Please ask for: Nicola Moore
Email: nicola.moore@arun.gov.uk
Telephone: Ext 37944
Our Ref: AW/53/22/T
Your Ref:
Date: 1st March 2022

Application for Works to Trees(s) subject to a Tree Preservation Order(TPO)

Development: This application relates to work on 1x Monterey Cypress tree, identified as tree number 4 on the accompanying plan at 11, Waters Edge, Aldwick. The application is to undertake a partial crown lift so that the lower crown is uniform around the entirety of the tree i.e. lift the lower crown on the eastern side of the tree to the same height as that on the western elevation. This will mean lifting the lowest part of the tree crown by approximately 3 metres. The reason for doing this is to retain the formal shape of the tree. No crown reduction work is proposed as part of this application.

Location: 11 Waters Edge Aldwick PO21 4AW

Document 1 - Plan

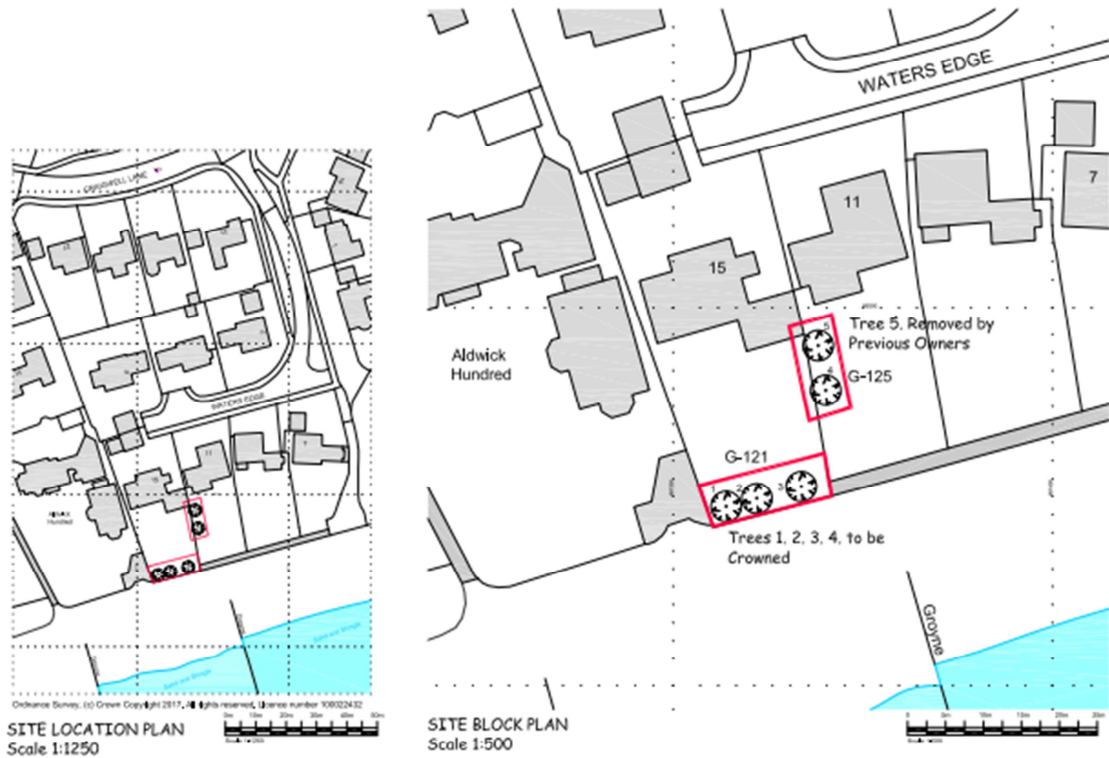
Please specify the height above ground to which you wish to lift the eastern crown.
